**Multi-Trades and Digital Technology Hub at TAFE Meadowbank Mod 1 (SSD-10349-Mod-1)
Request for Additional Information**

I refer to the Multi-Trades and Digital Technology Hub at TAFE Meadowbank (SSD-10349-Mod-1). After careful consideration, the Department is requesting that you provide additional information.

PROPOSED SITE PLAN SOUTH

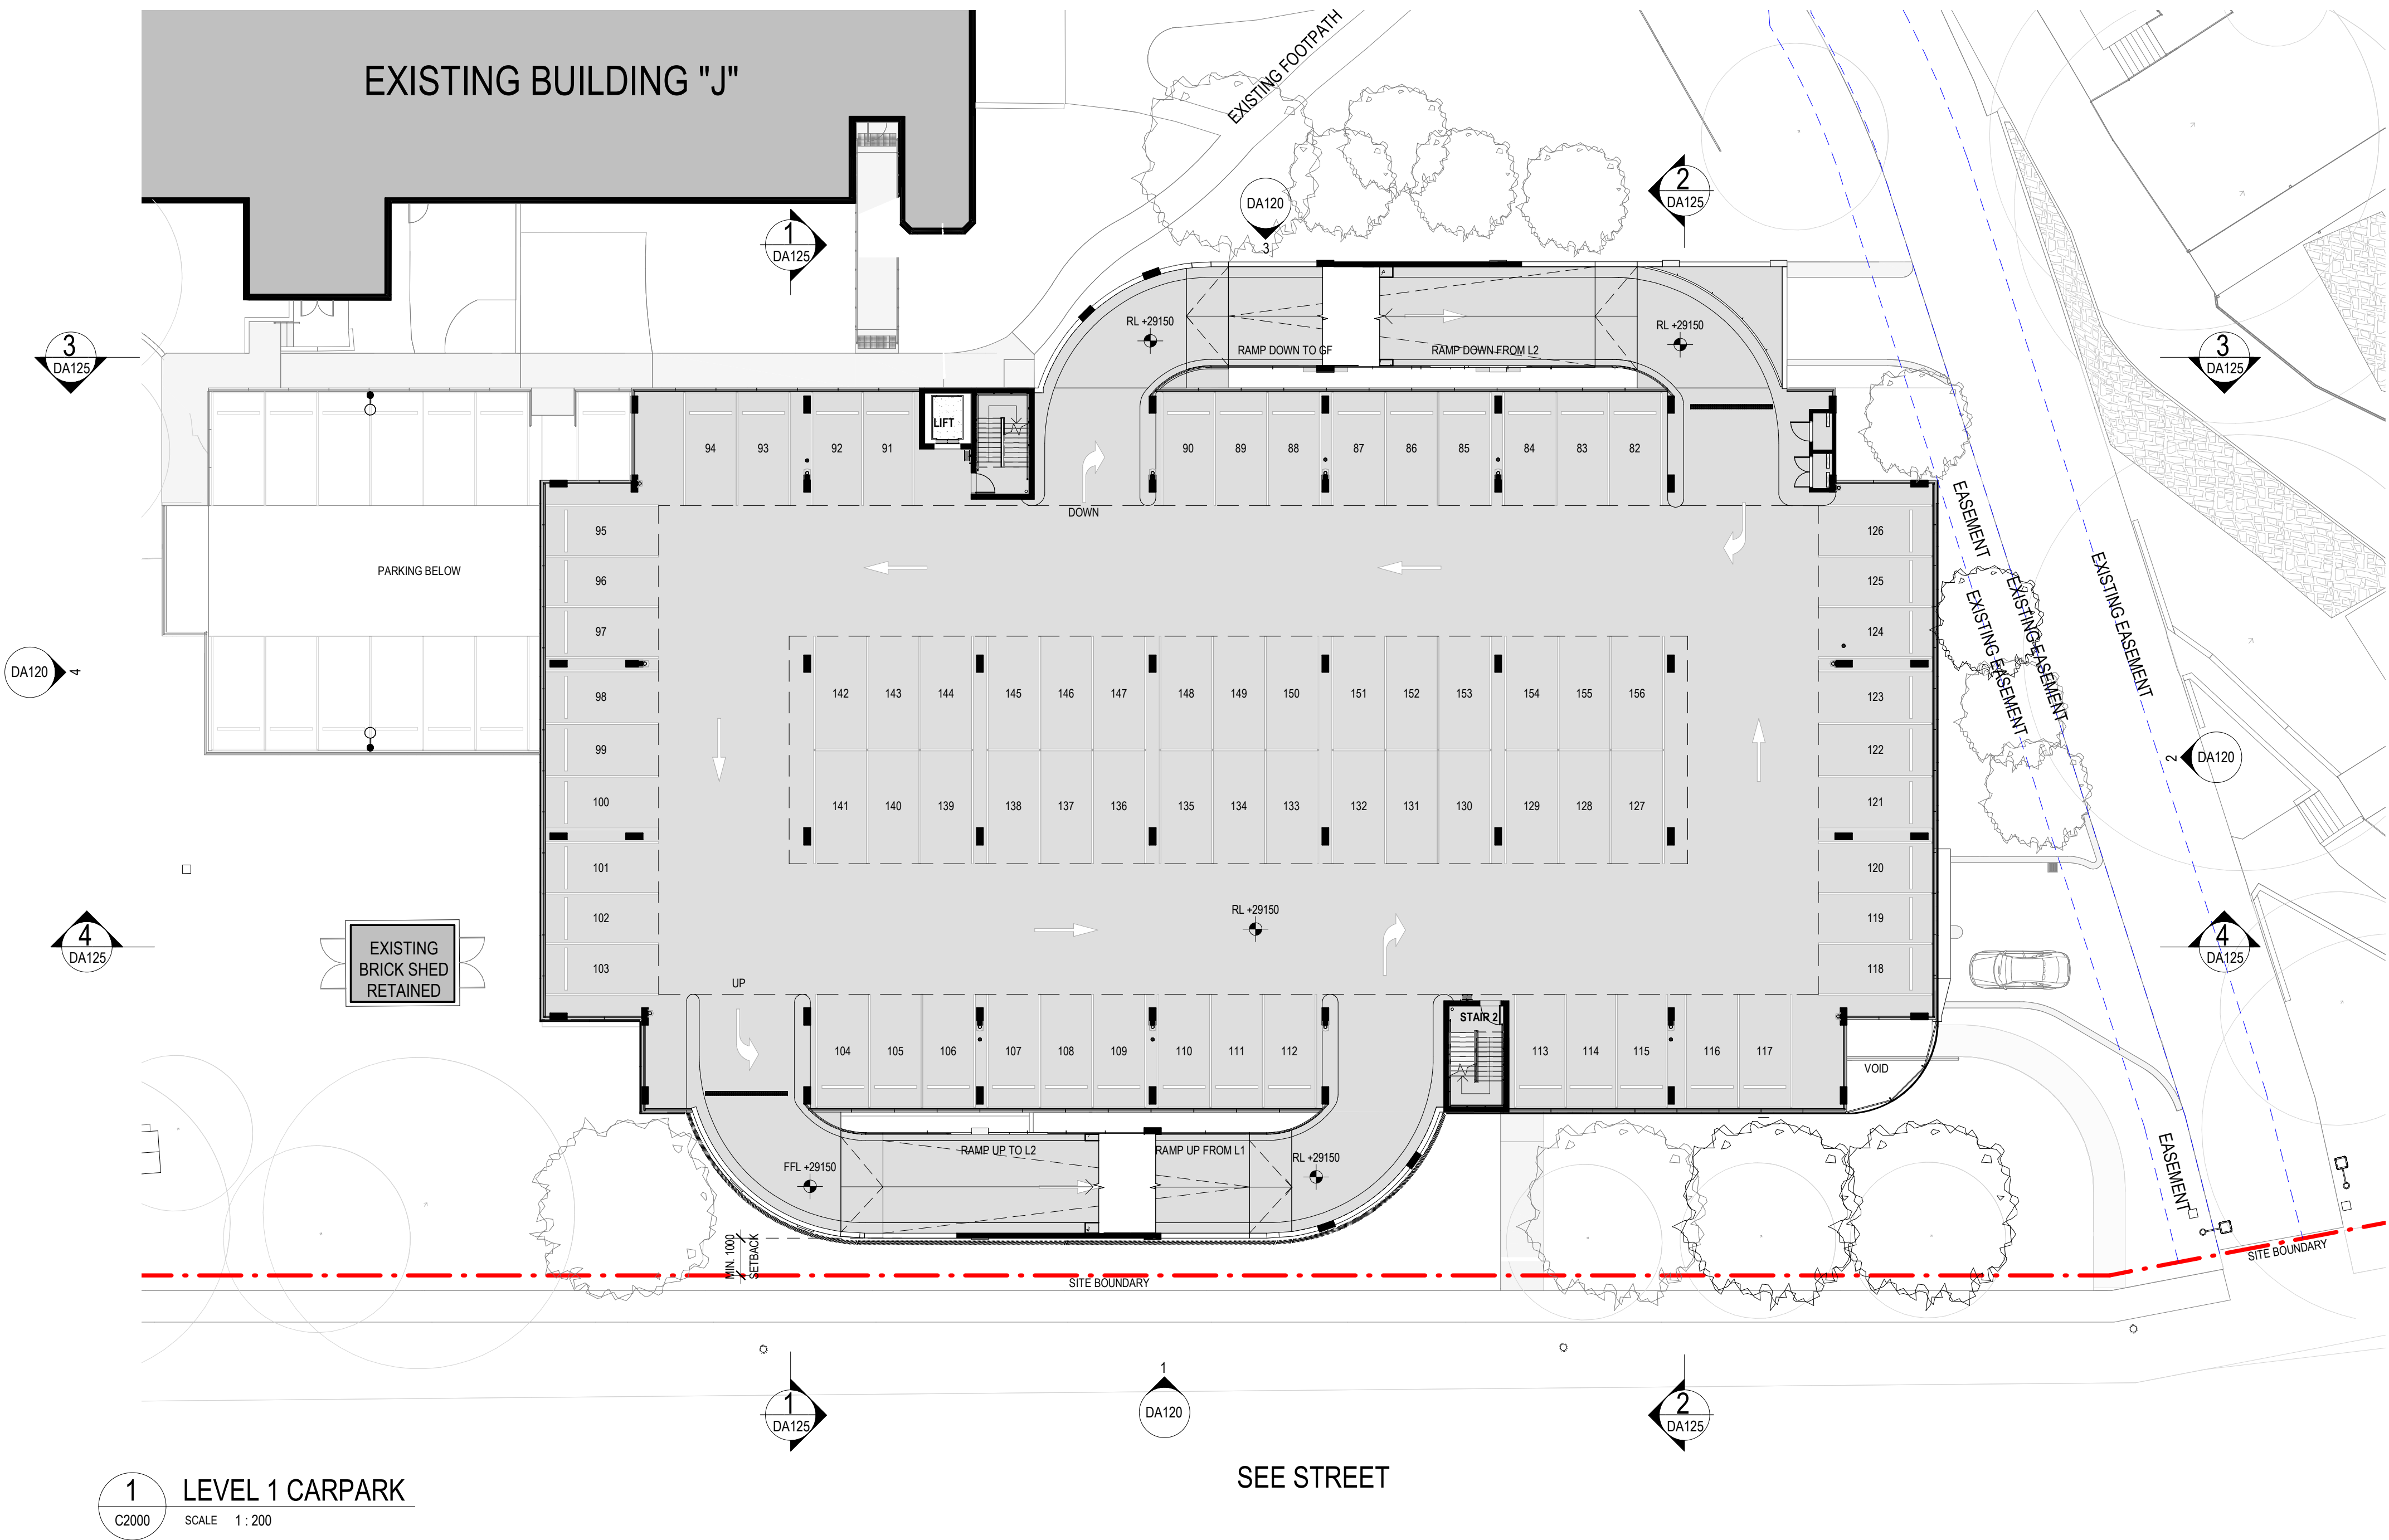
- a request for a new Biodiversity Development Assessment Report Waiver in accordance with section 7.16 of the *Biodiversity Conservation Act 2016*.
- updated plans ensuring that all plans appropriately depict the removal of the additional trees proposed as part of this modification.
